Application No: BR/39/26/PL
Site Address: Bognor Regis Sports Ground Hawthorn Road Bognor Regis PO21 2UW
Description of works: Replacement of existing 1.8m high fence panels along the perimeter of the sports ground (north and east) with a new 3m high green metal twin bar fence. This application is in CIL Zone 4 (Zero Rated) as other development.

Thank you for your internet representation made on 31st May 2026 which has been recorded as an objection with the comments as follows:

Proposed Fencing Layout
and Elevations

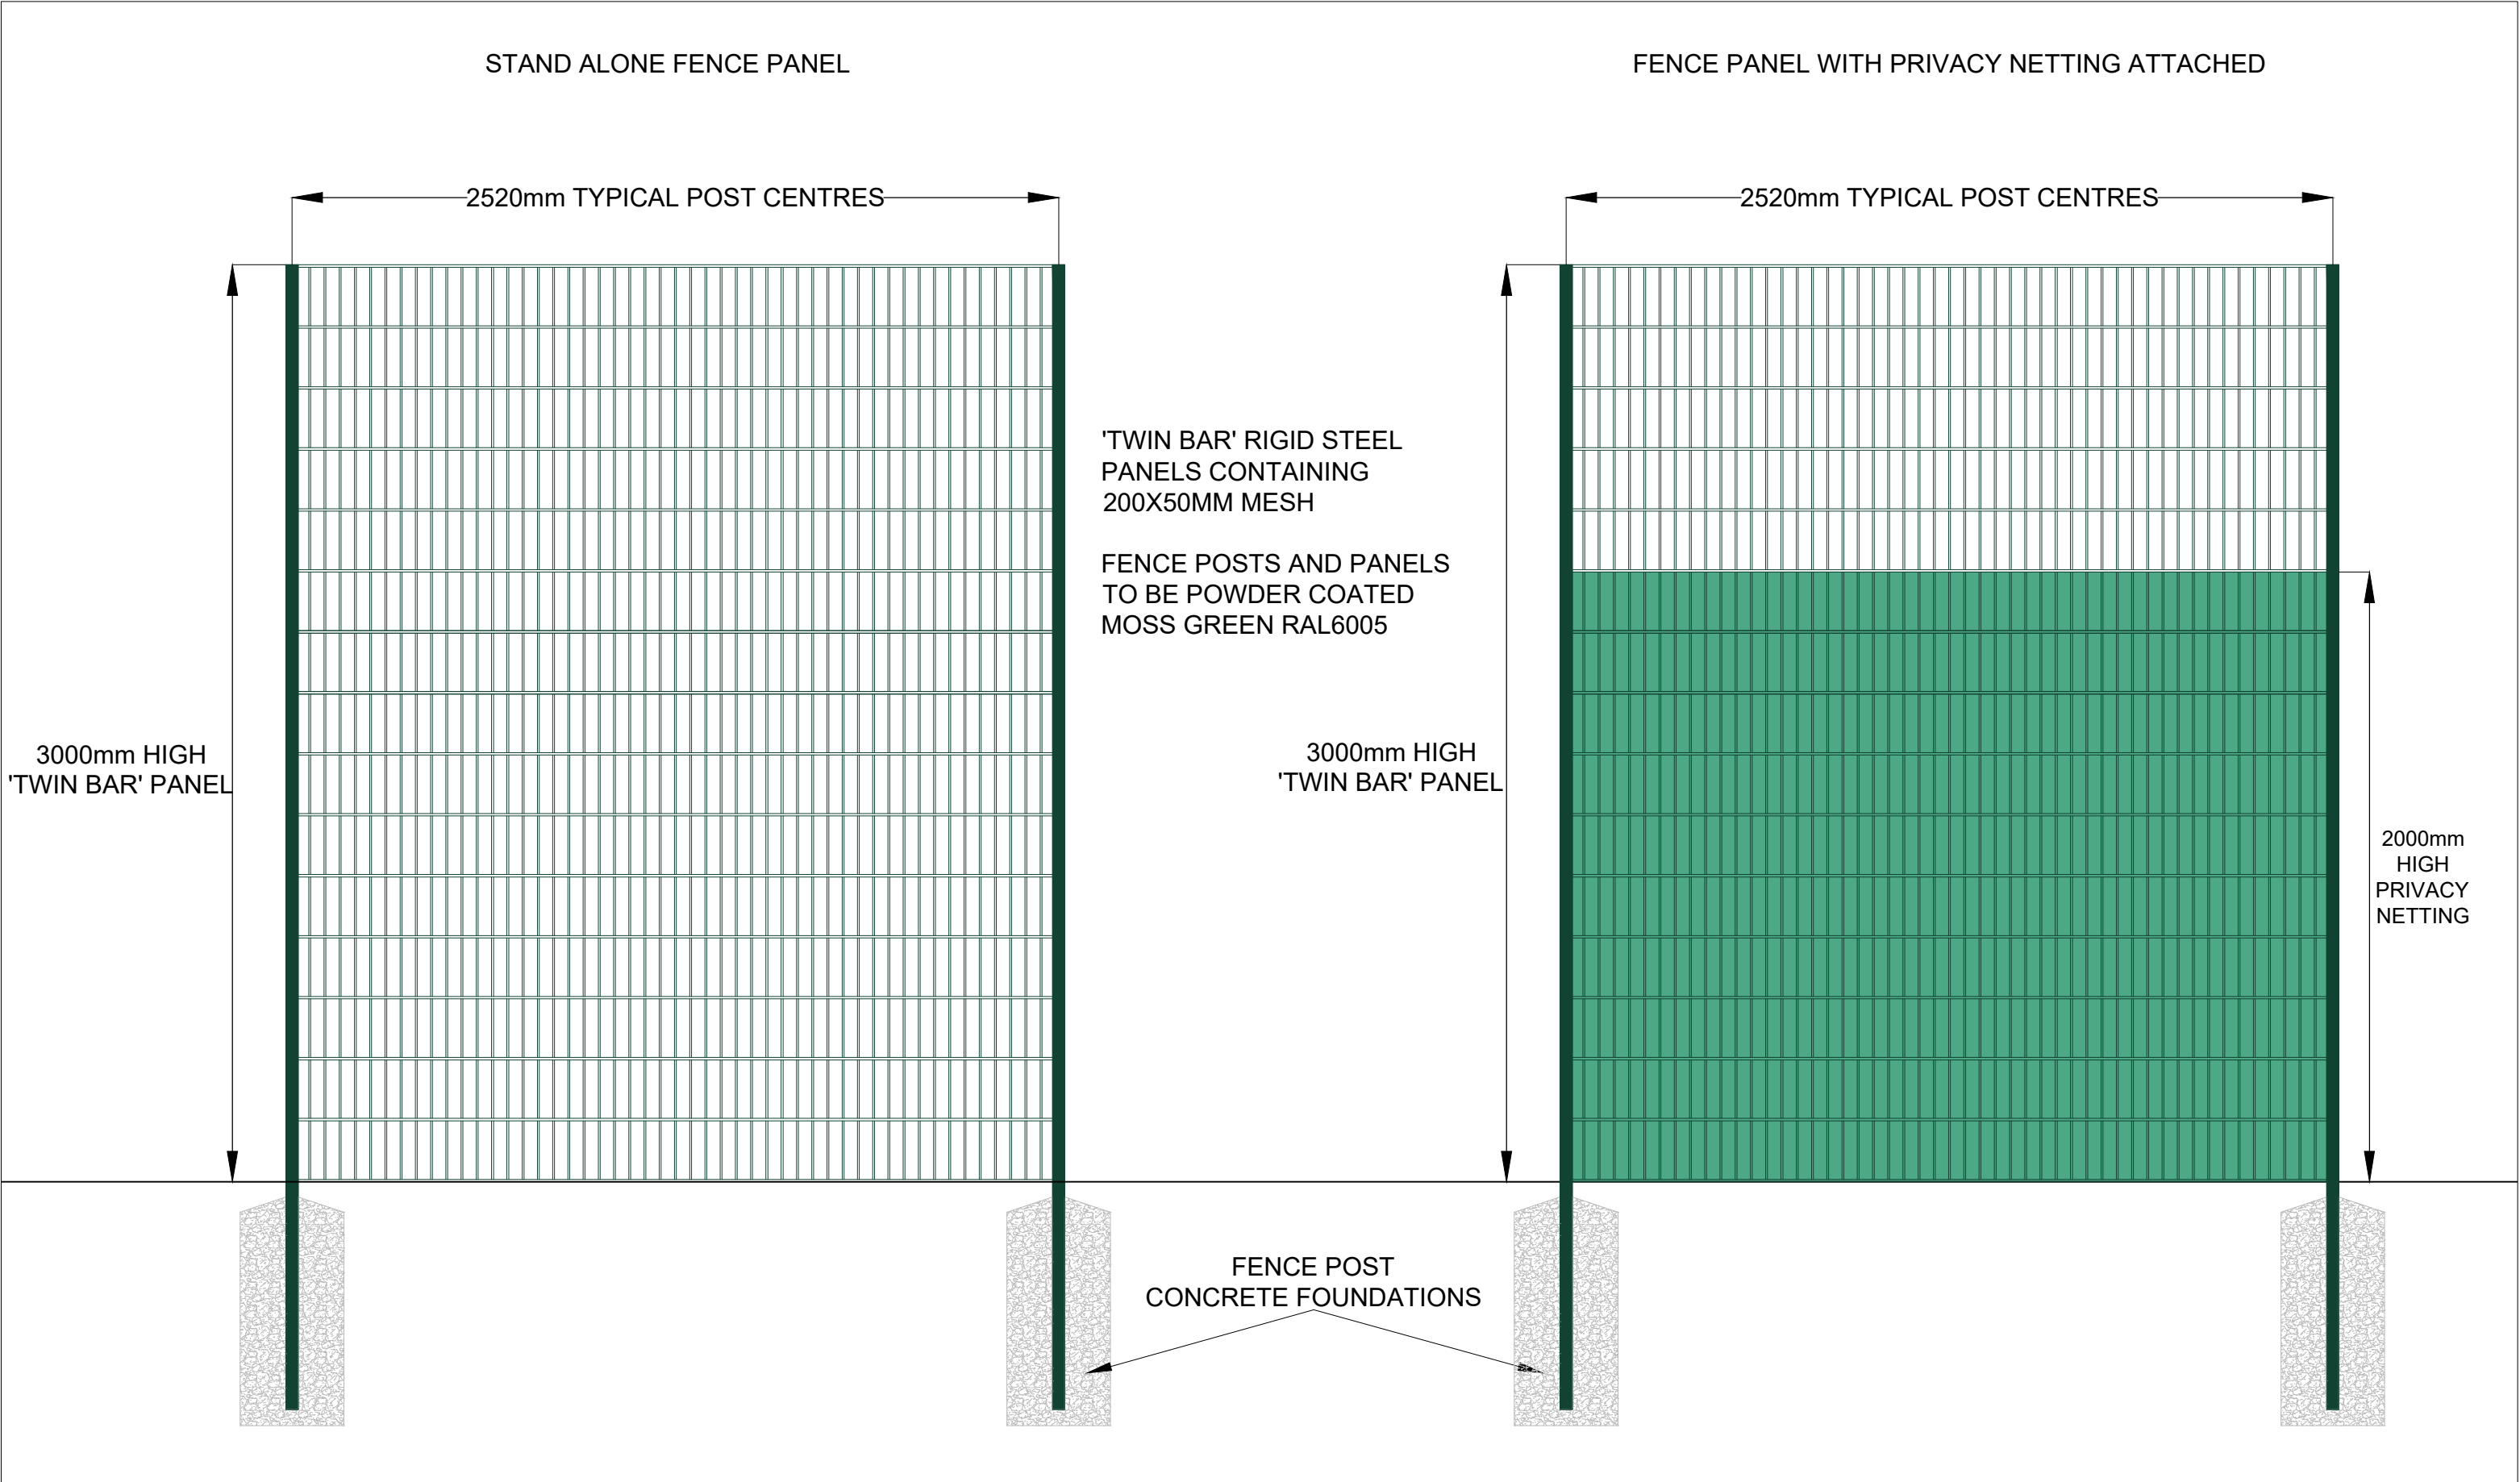
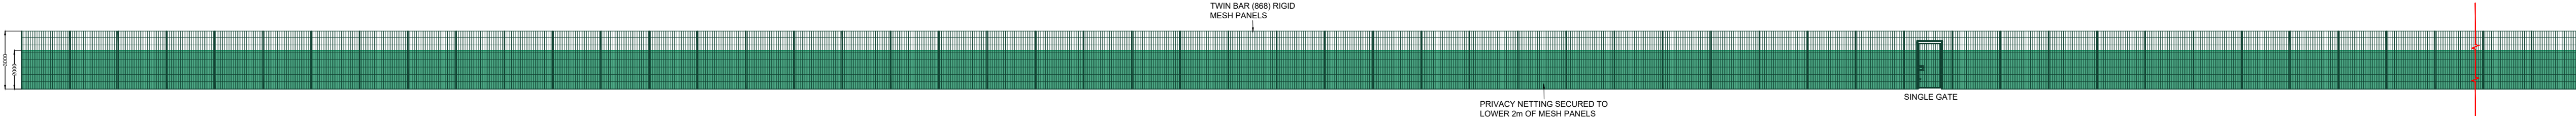
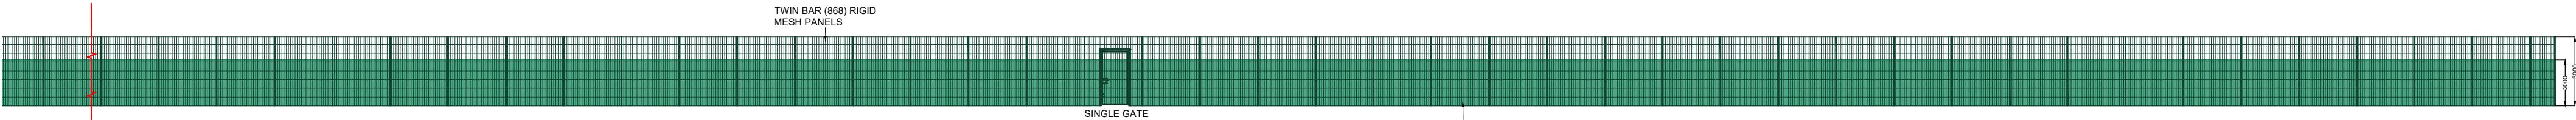
We live in Nyewood Lane directly across from the sports ground and are concerned about the height of the fence blocking our view of the sports ground and open-ness of the space generally.

We are also concerned about the type of fence proposed to be used.
We currently have fencing that allows both light and viewing through it and are concerned the new fencing will not allow either.
